20th February 2013

Application for Householder Planning Permission

Development	Demolition of existing extension and outbuildings and new single storey extensions.
Location	Well Gardens Norton Lane Aldingbourne

PROPOSED ELEVATIONS

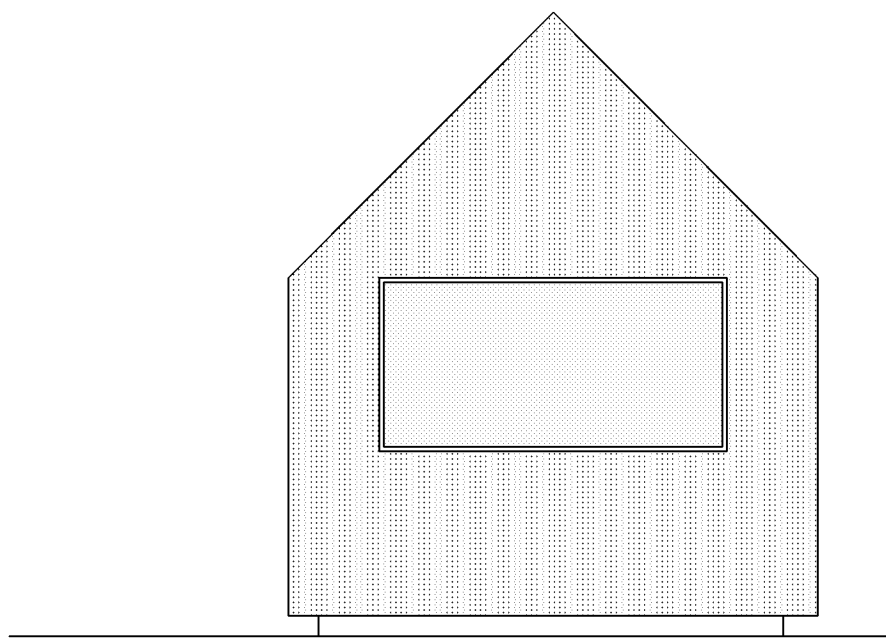
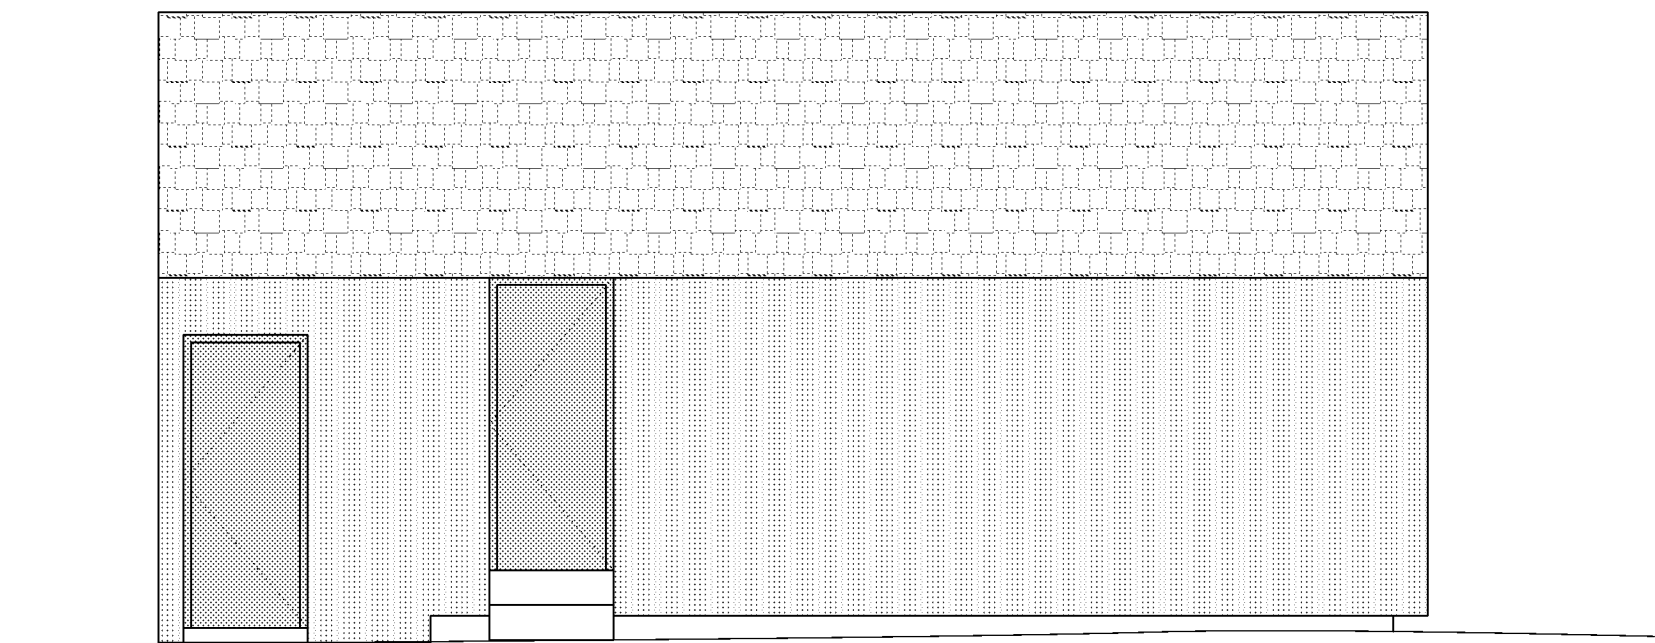
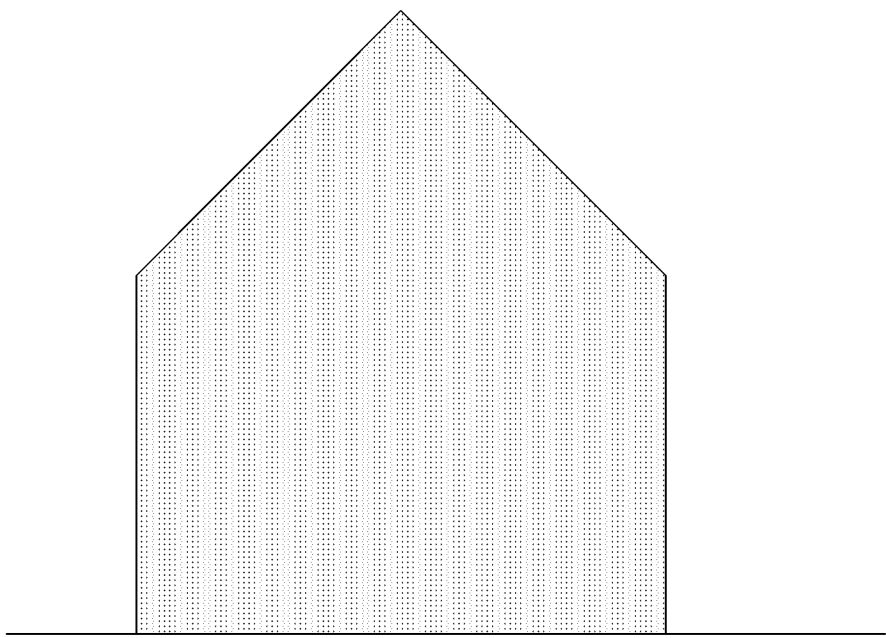
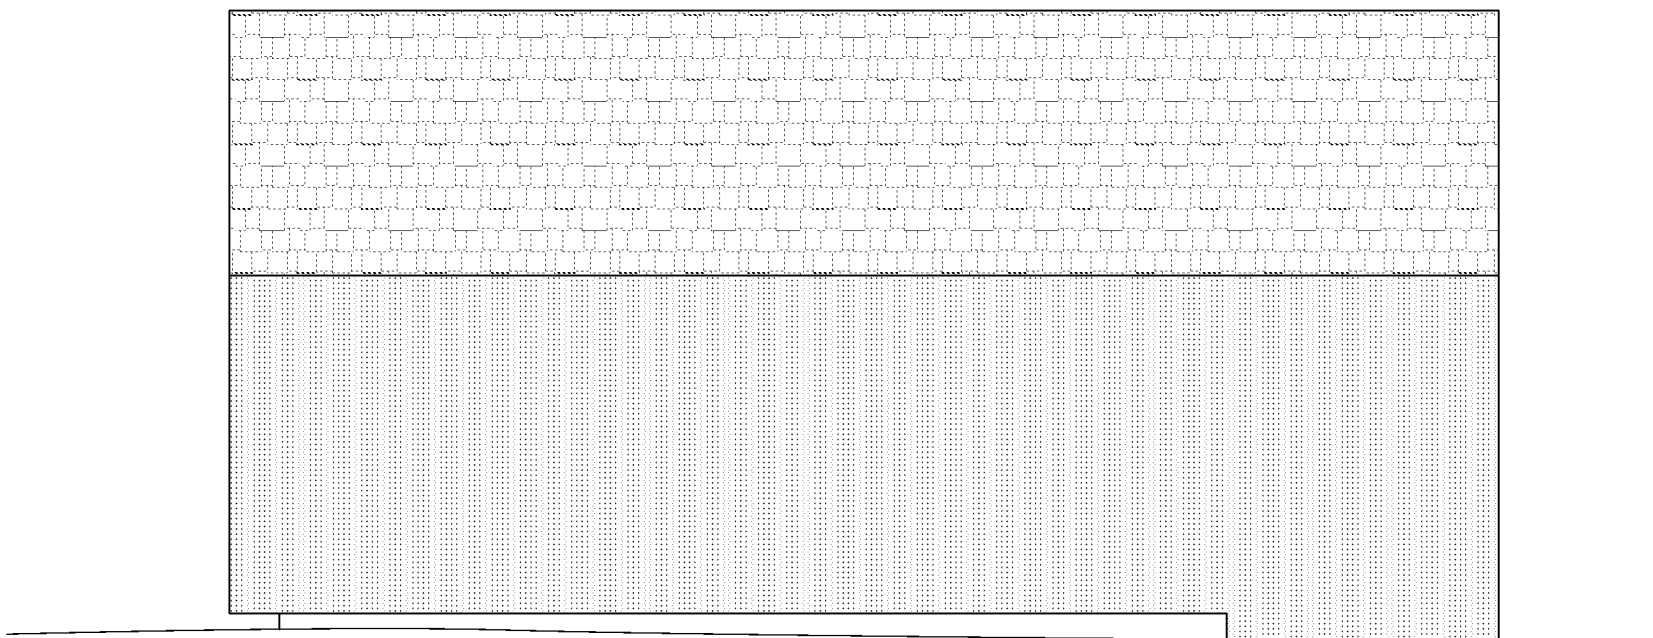
Please provide the missing two elevations for the proposed guest building.

EXISTING ELEVATIONS

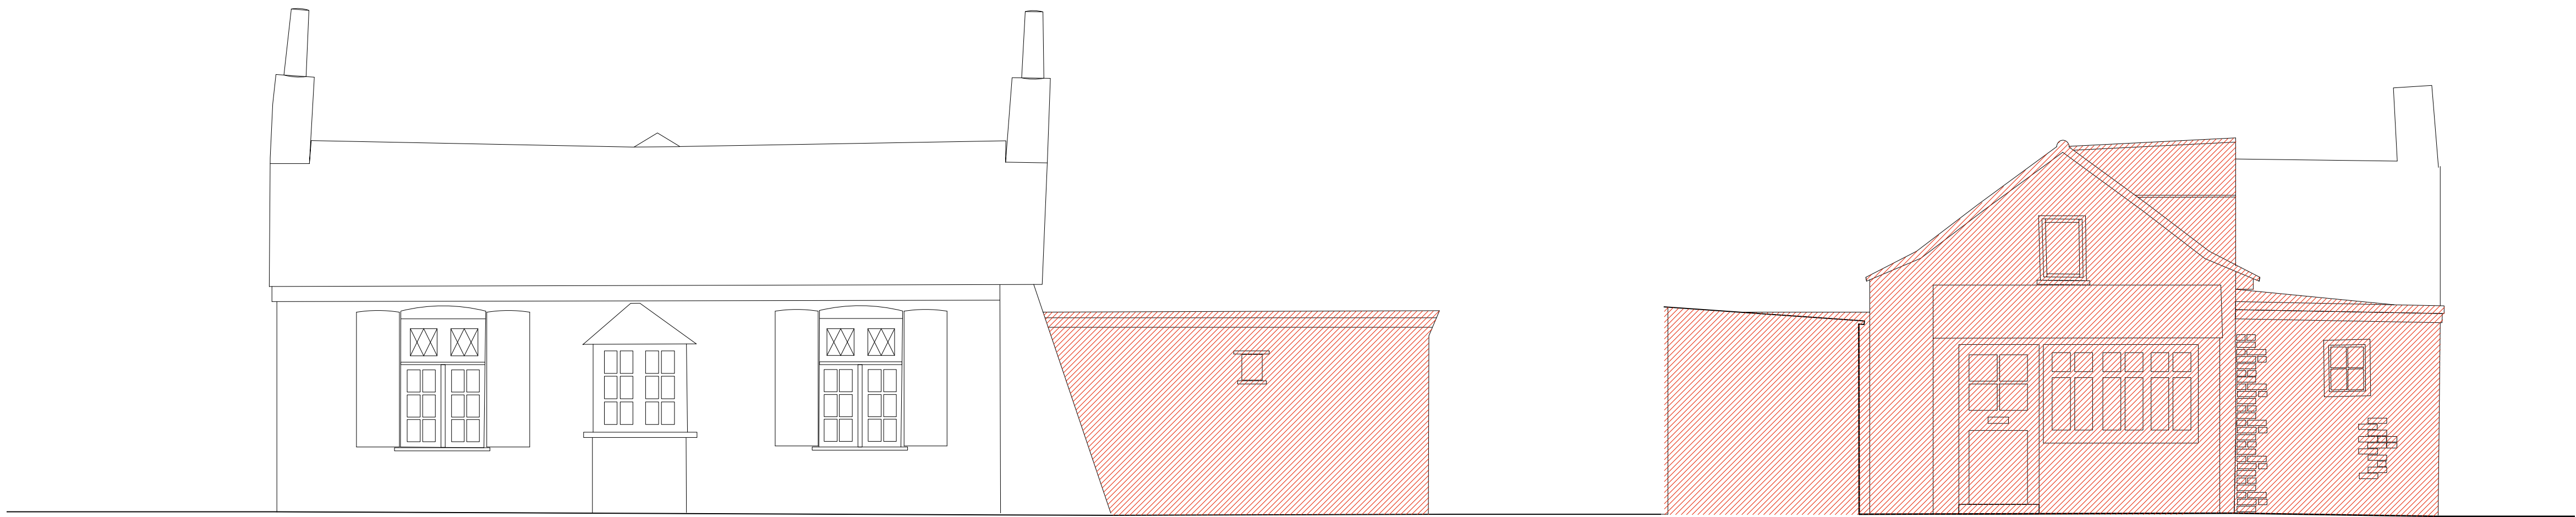
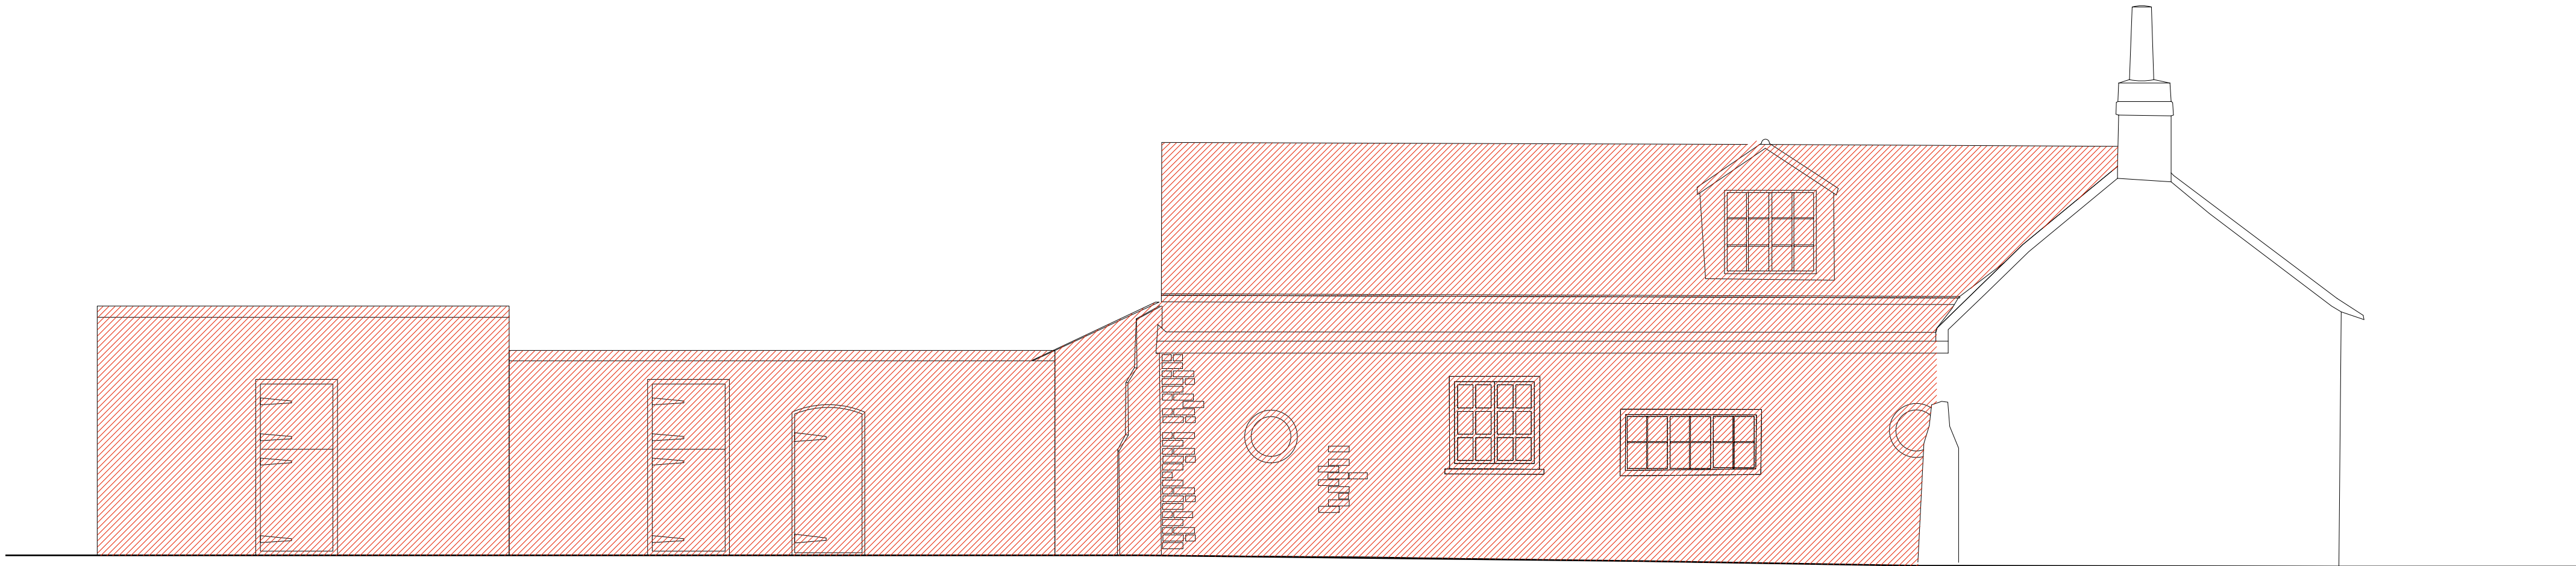
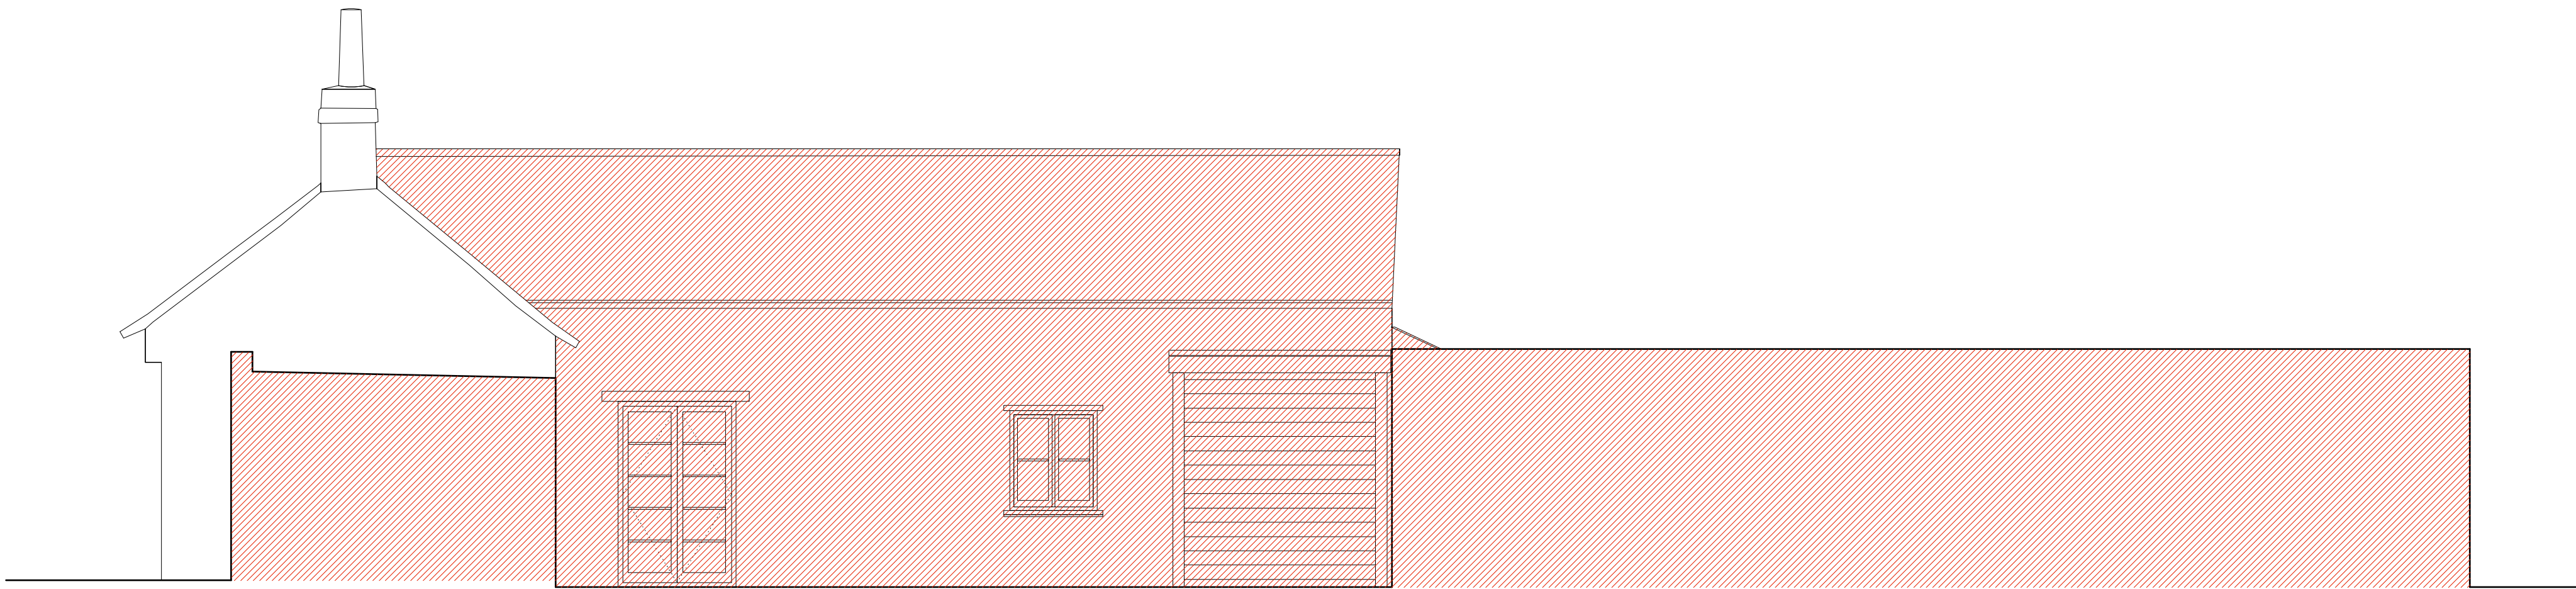
Please confirm if on Existing Elevation 04 (PO4B) is a door or ship lap finish.

The existing plans and existing elevations (rear, side and front) do not accord (Plans PO2B and PO4B). Please amend accordingly.

EXISTING SECTIONS AND ELEVATIONS

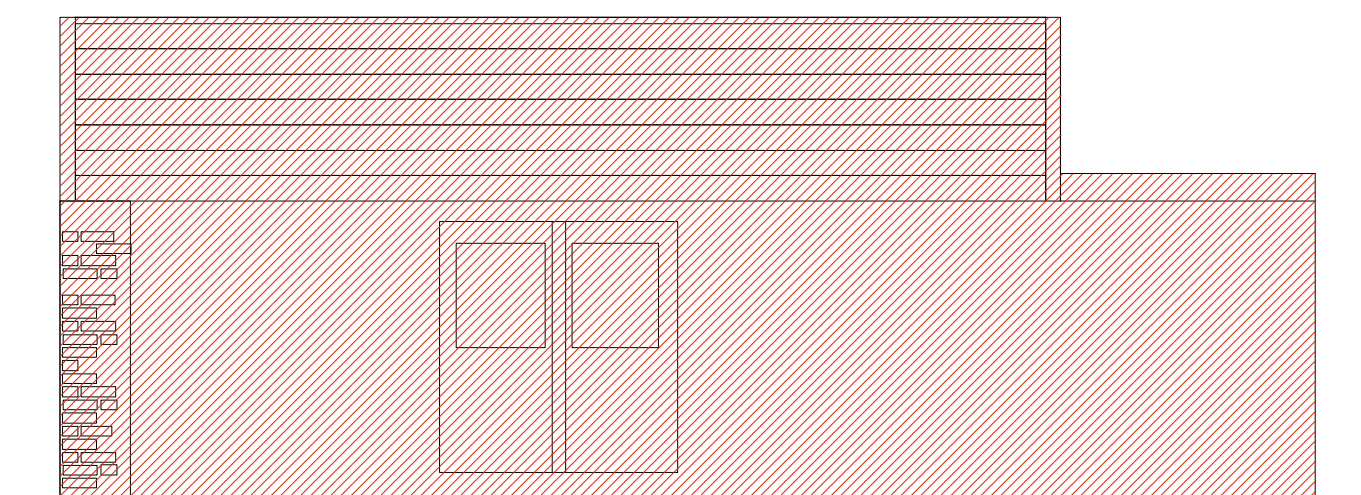
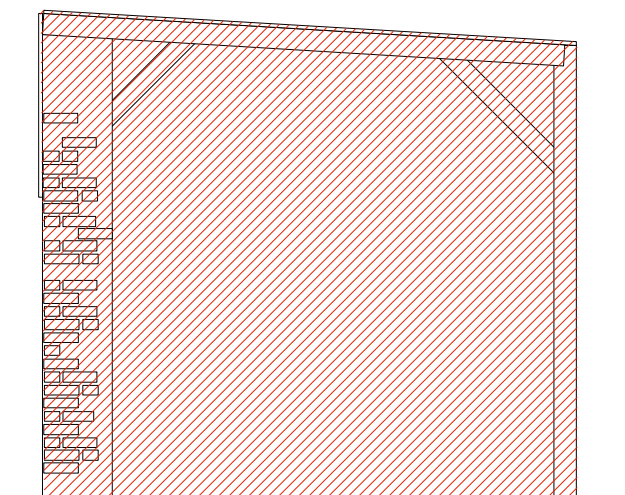
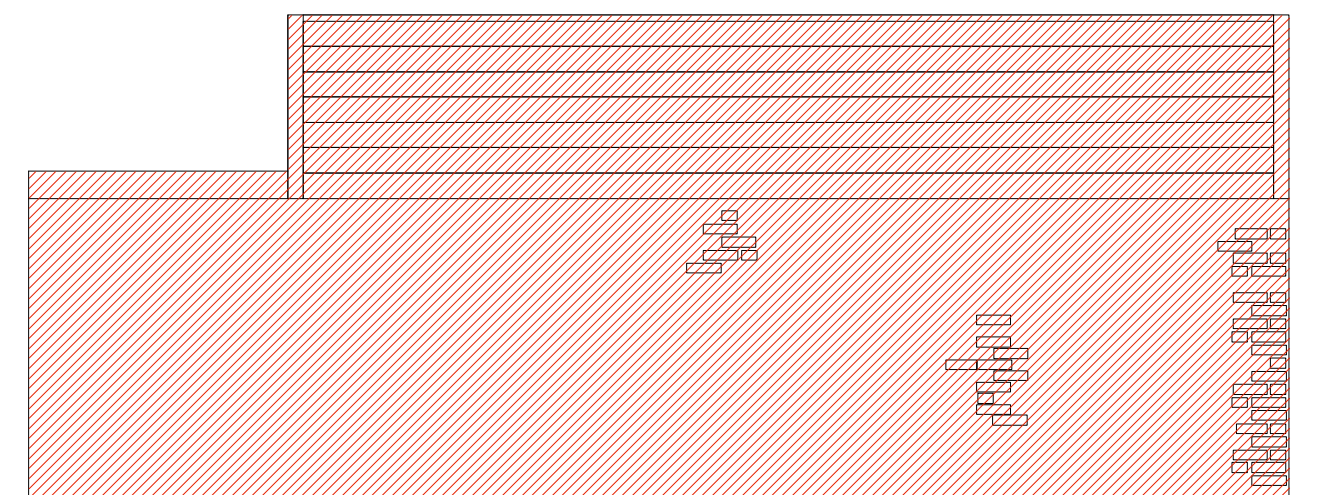
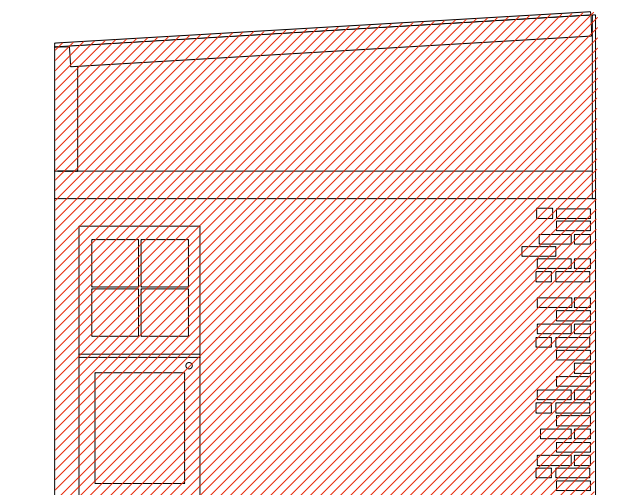
Please provide existing floor plans and elevations for the outbuilding (not the outbuilding that is attached to the house).
